From: Zac Denton
Sent: 10 October 2018 08:06
To: Amanda Scholes
Subject: RE: Representation on: LU/247/18/HH at 13 Norfolk Road

LONG SECTION

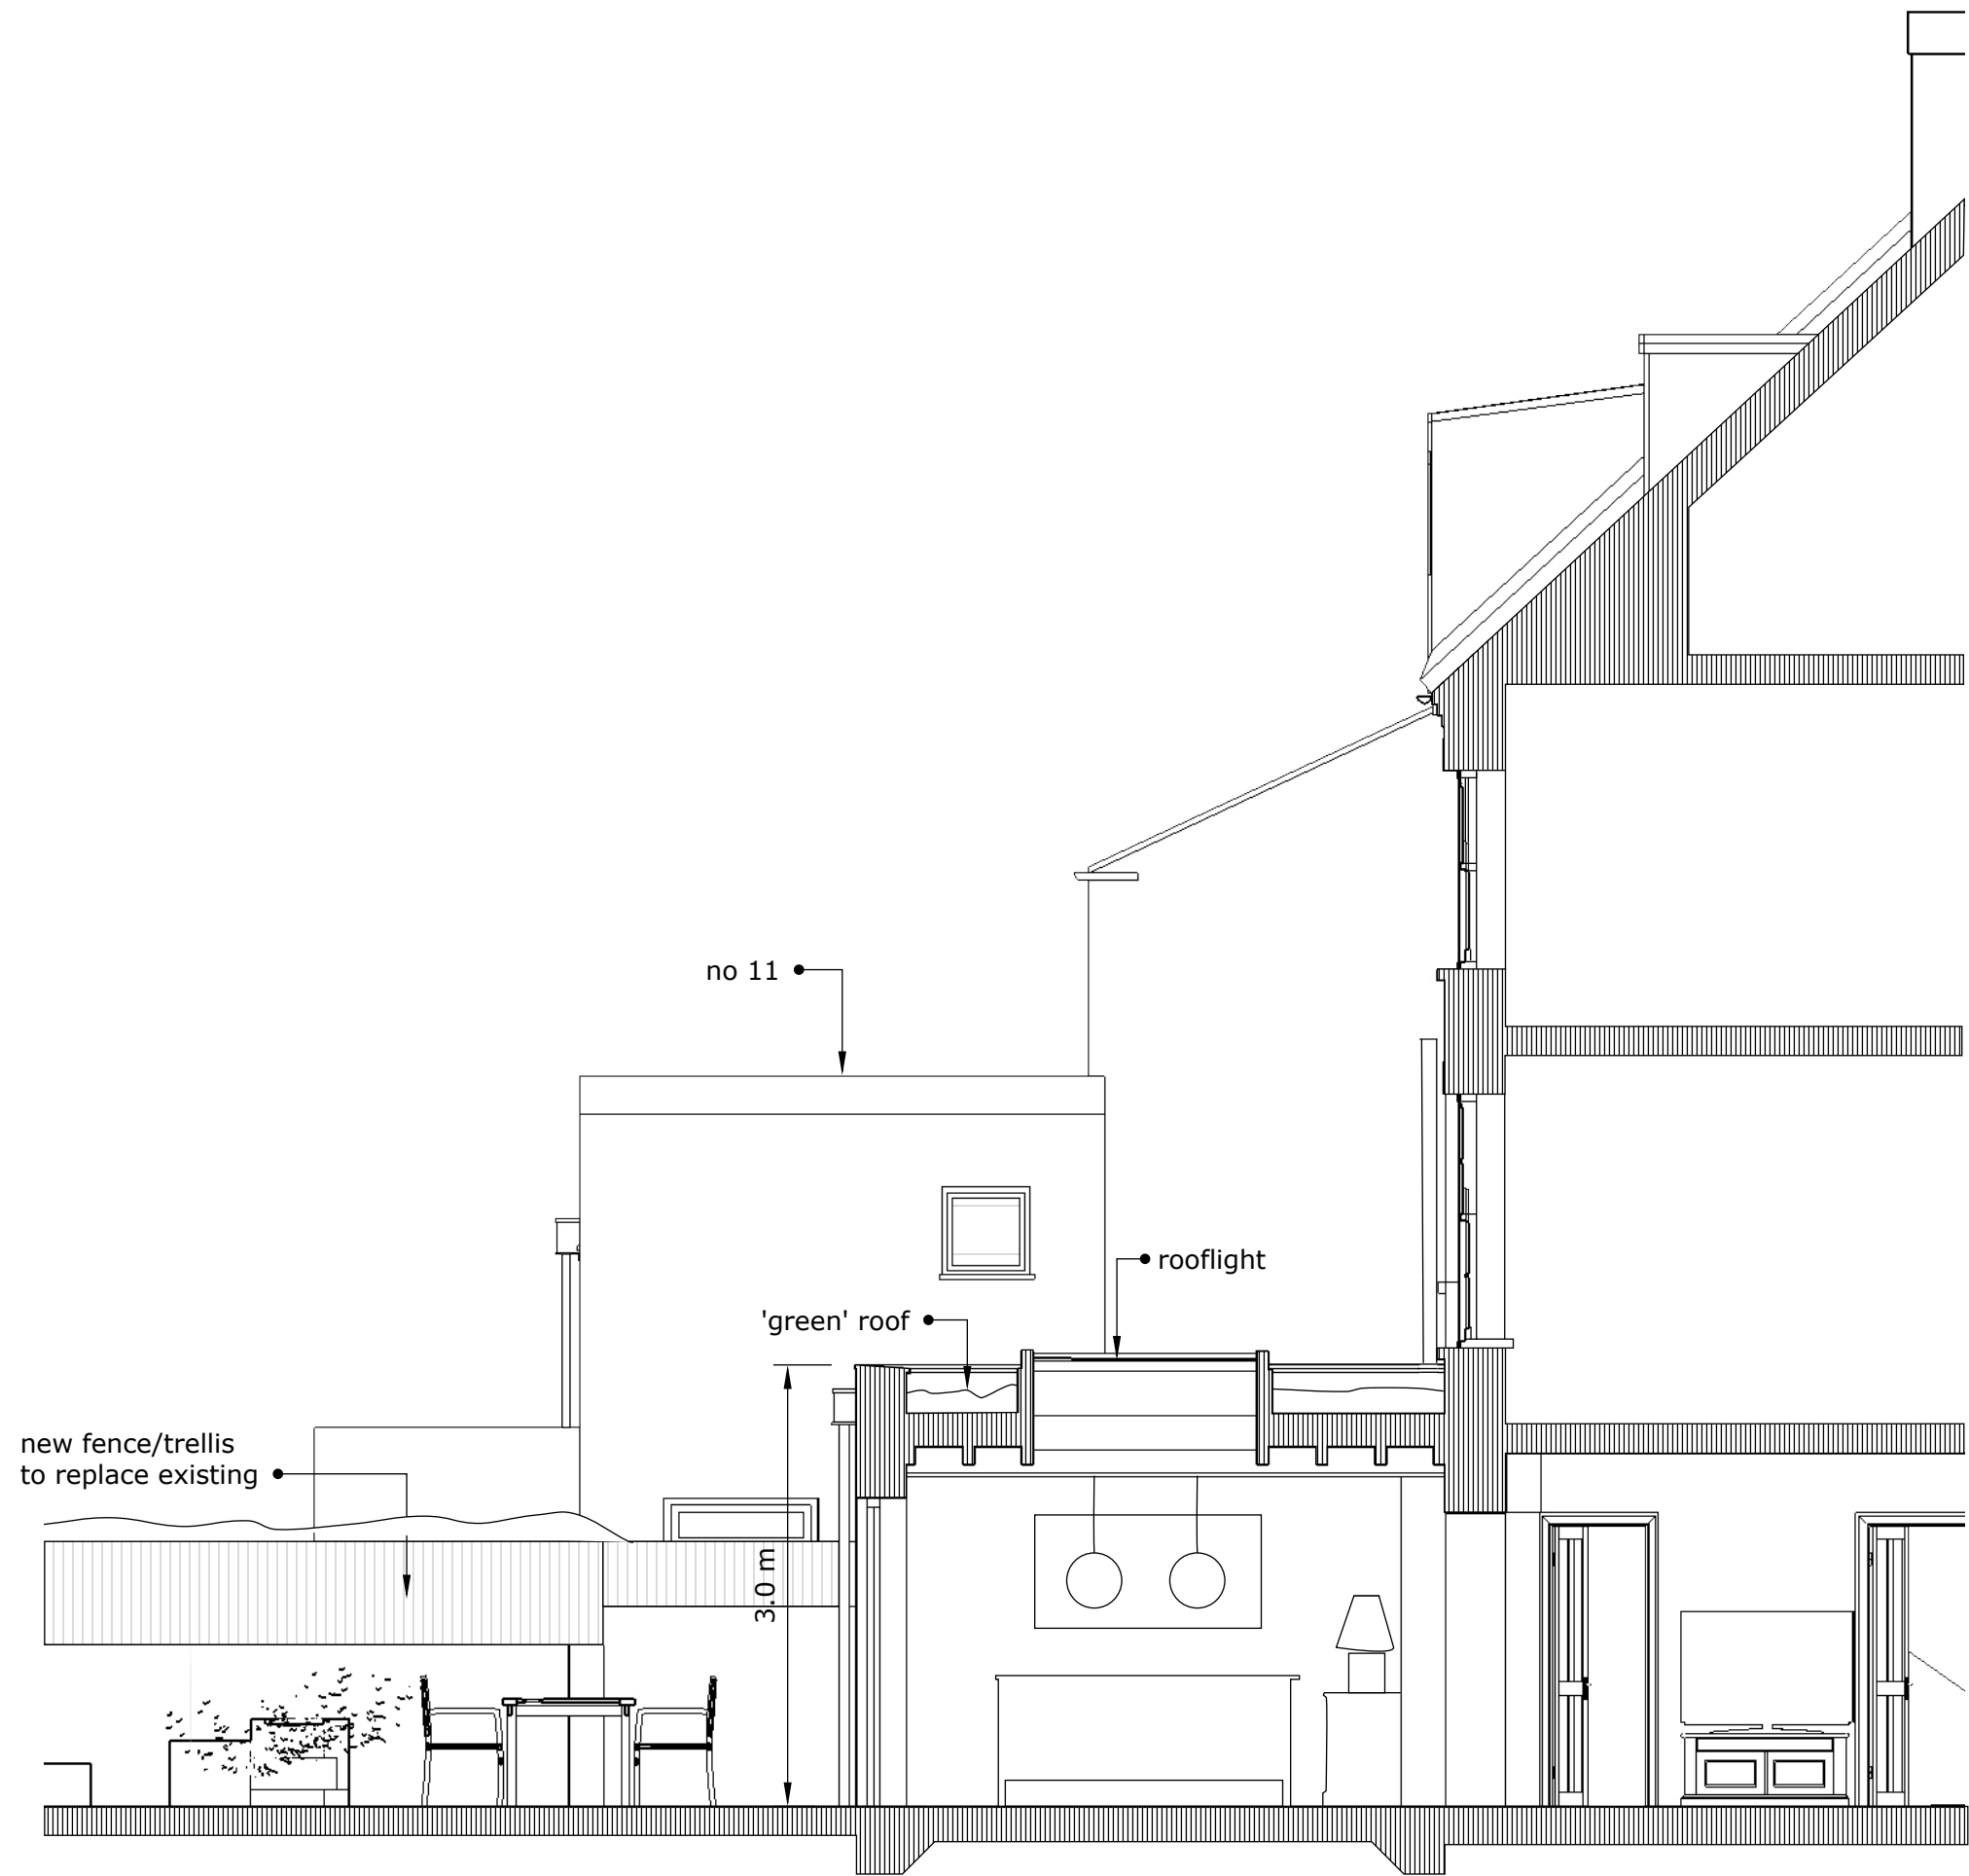
Question: What form of structural change is proposed to support the rear of no 13, taking into consideration the age and type of foundations this property has?

SOUTH ELEVATION Drg no 2018/MEL/04 Aug 2018 Scale 1:50@A3

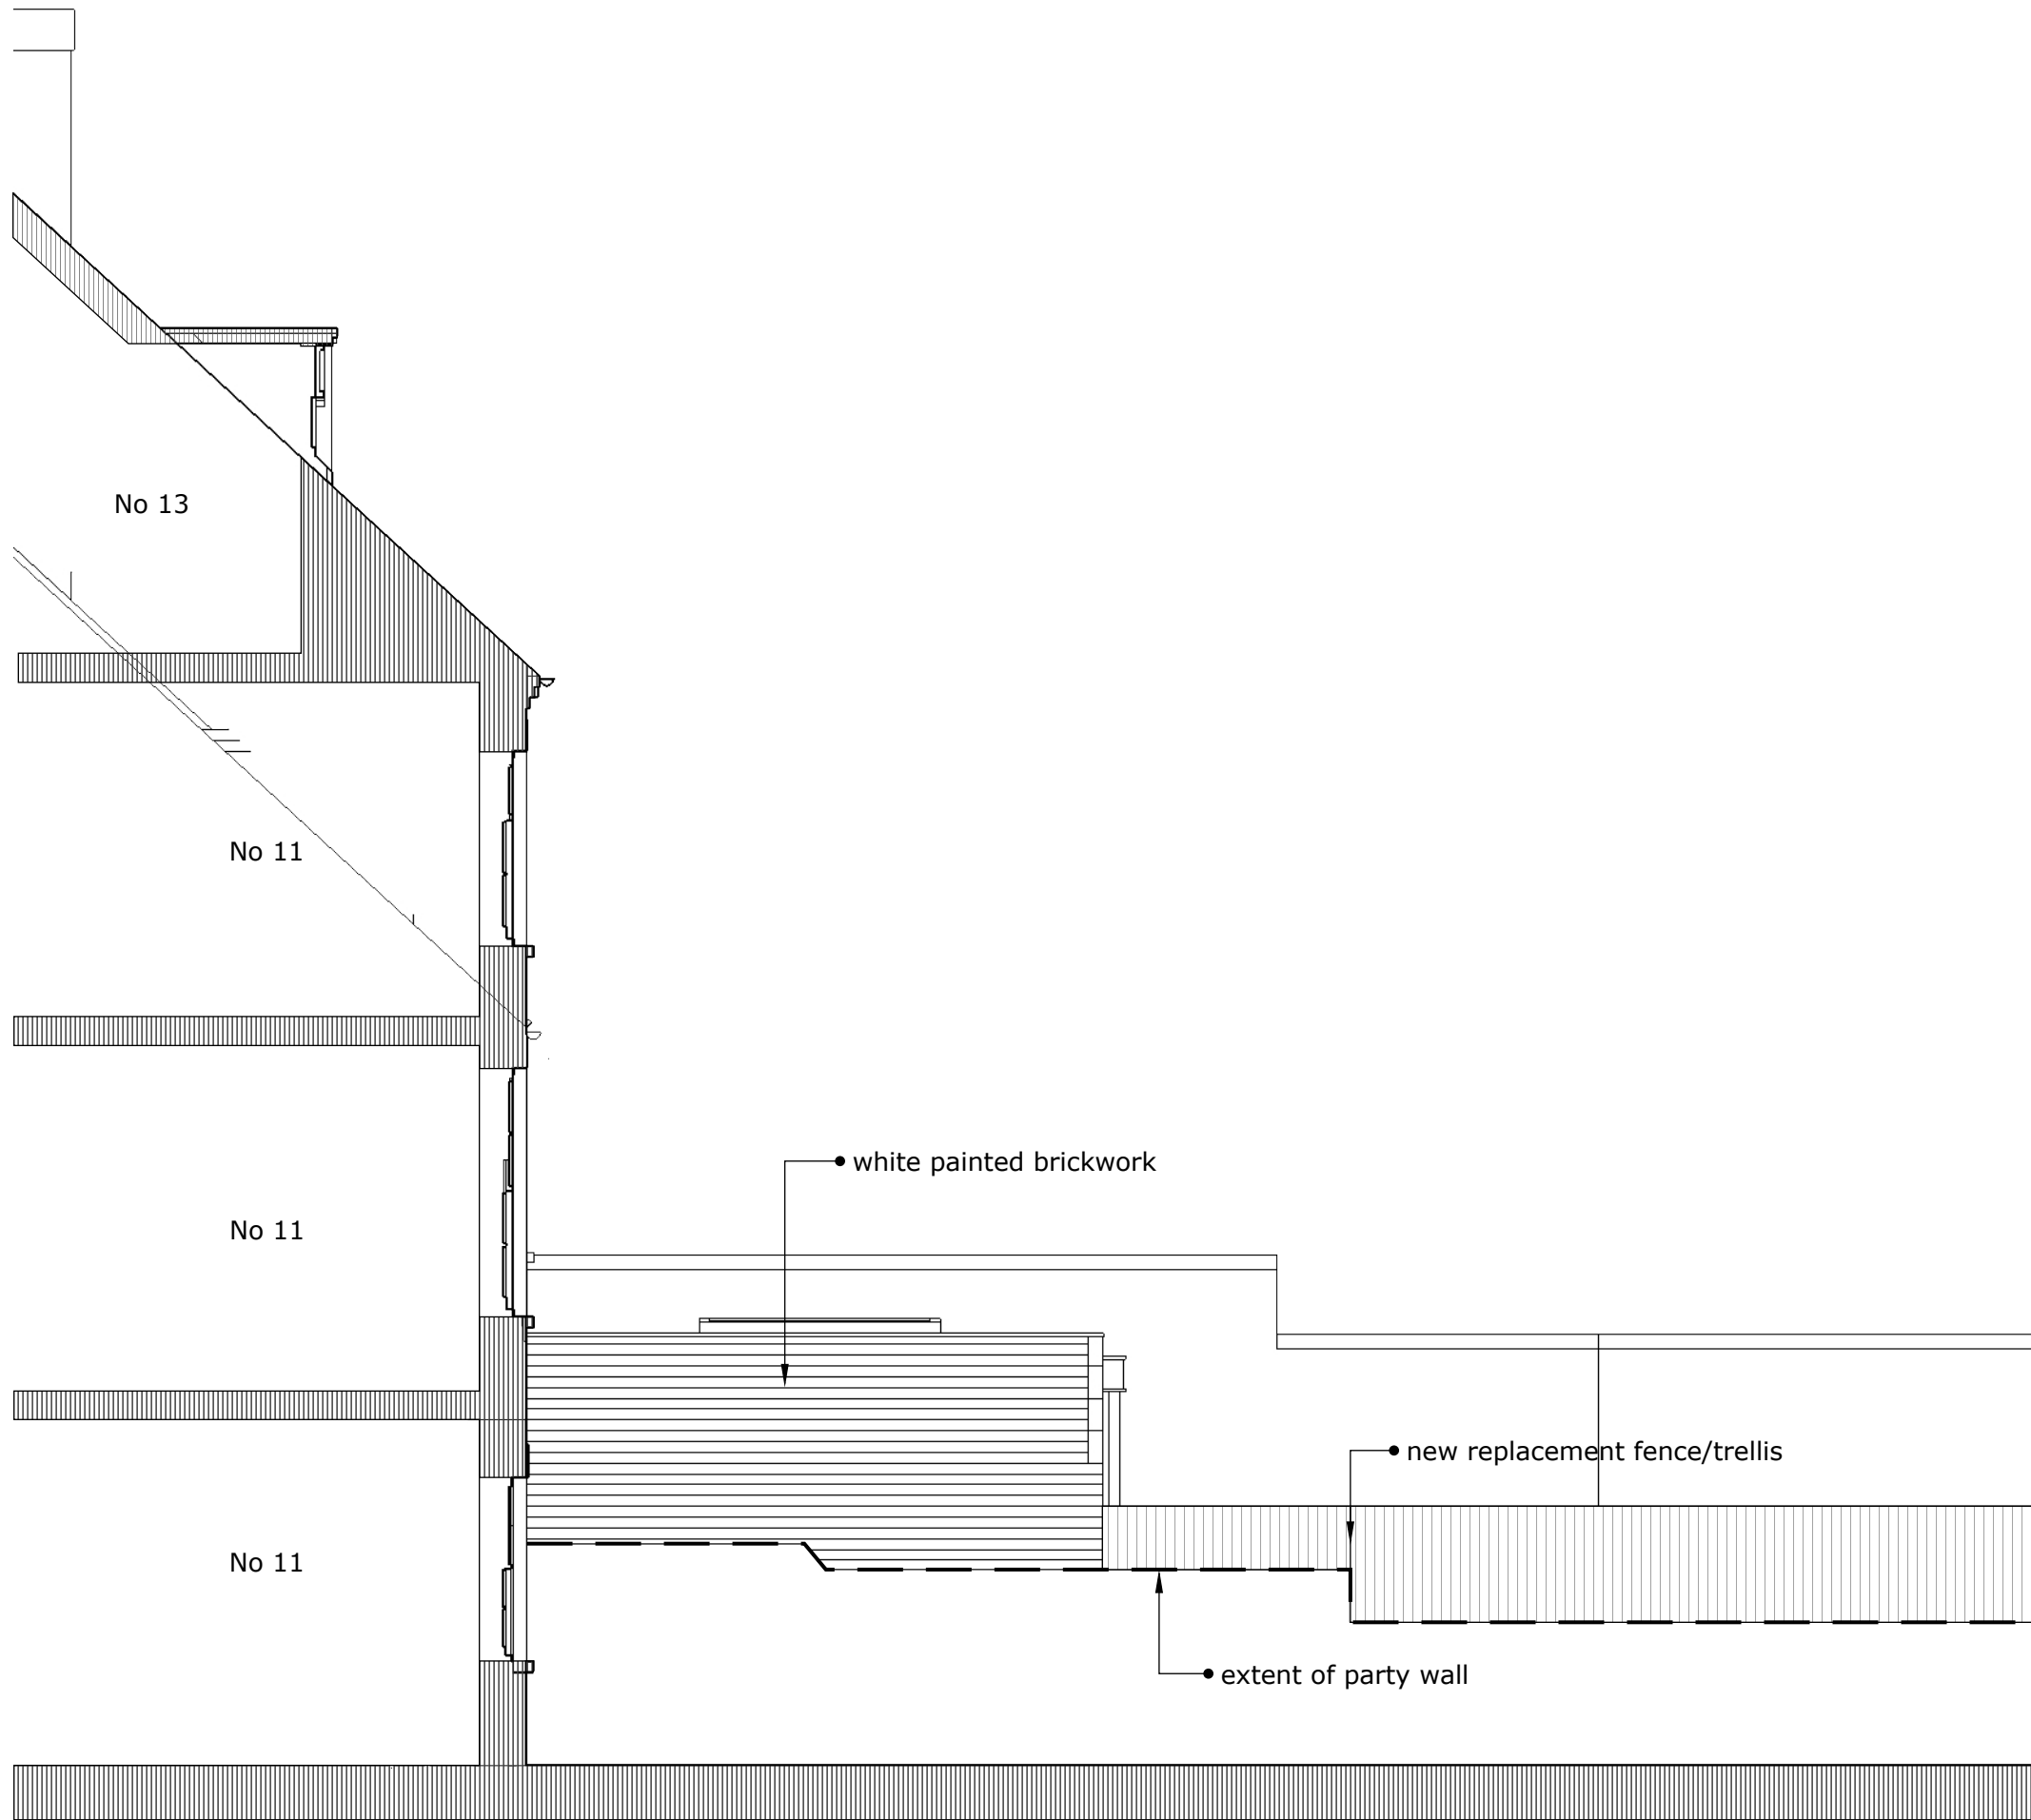
A/ Kitchen back door, part glazed for extra light would be overshadowed by the proposed 3 metre wall, which would be only ONE metre away.

C/ The adjoining fence mentioned in the proposed development, belongs to no. 11 and we would not like it to be removed for any reason without discussion and agreement.

PROPOSED GROUND FLOOR PLAN Scale 1:50

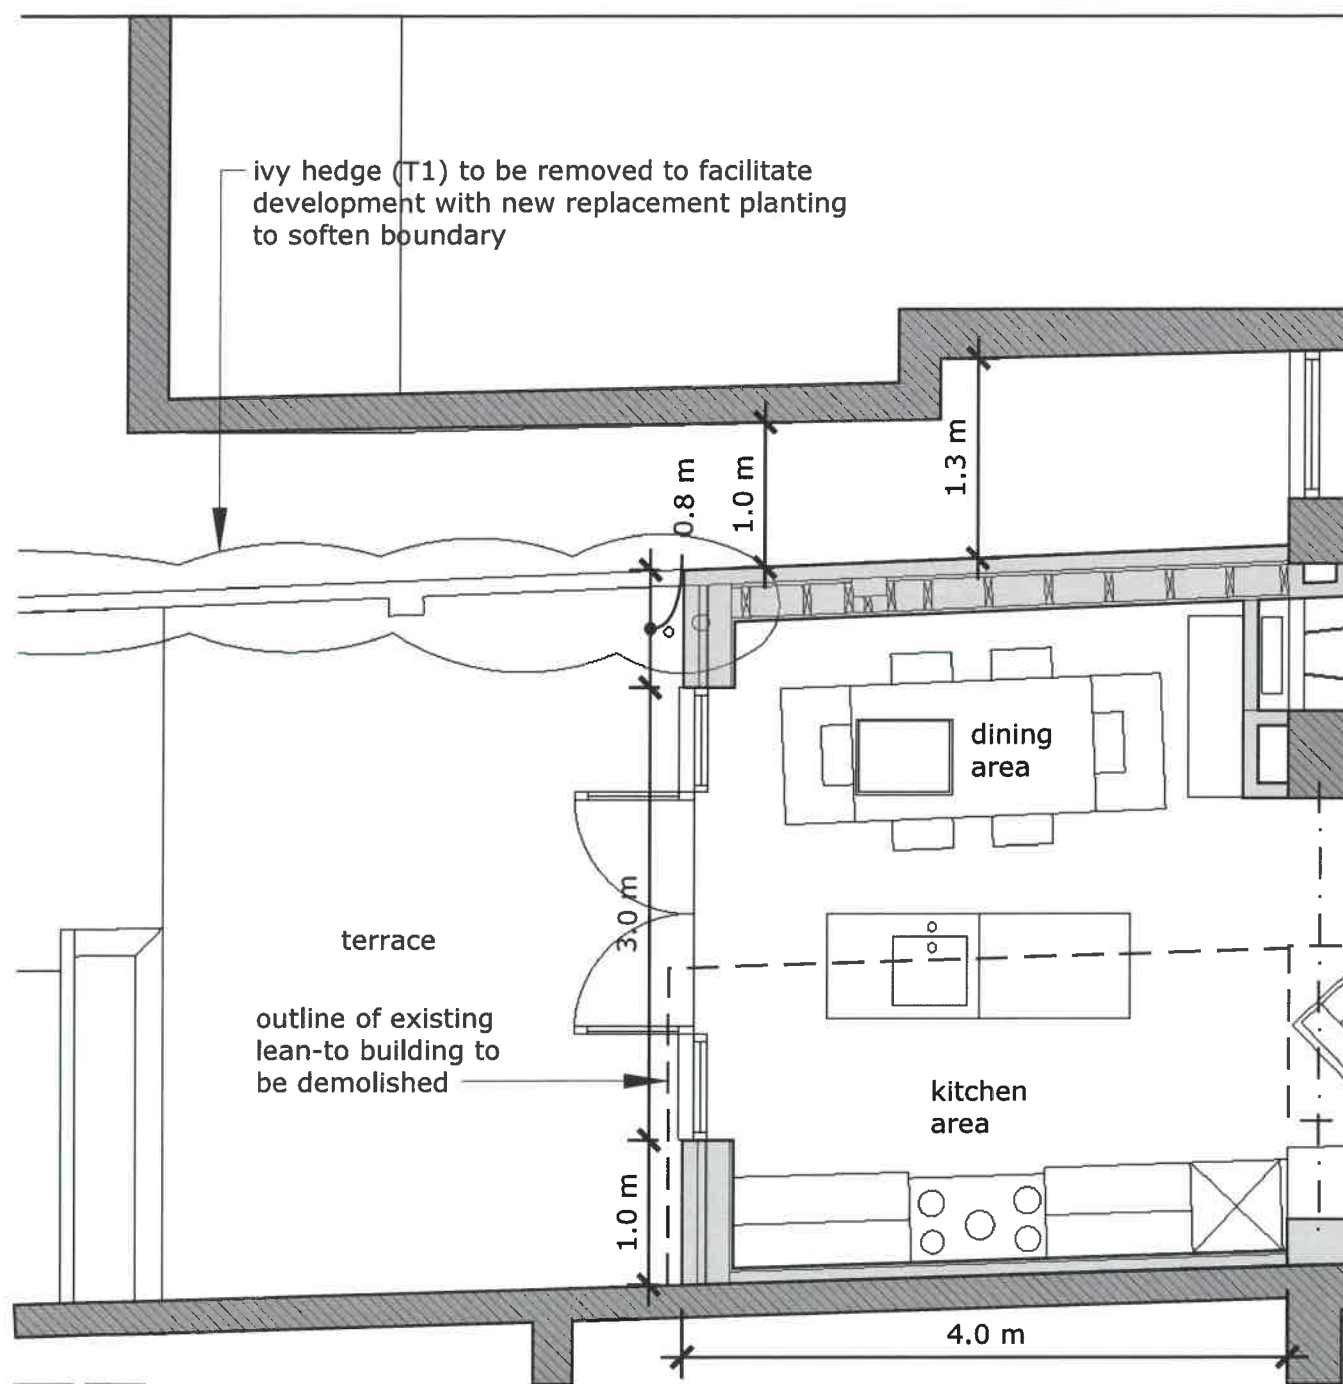
B/ Reference made to the two storey extension, we would like to point out, the extension is not of recent build, it was built in the early 1900's, many years before our neighbours purchased no. 13.
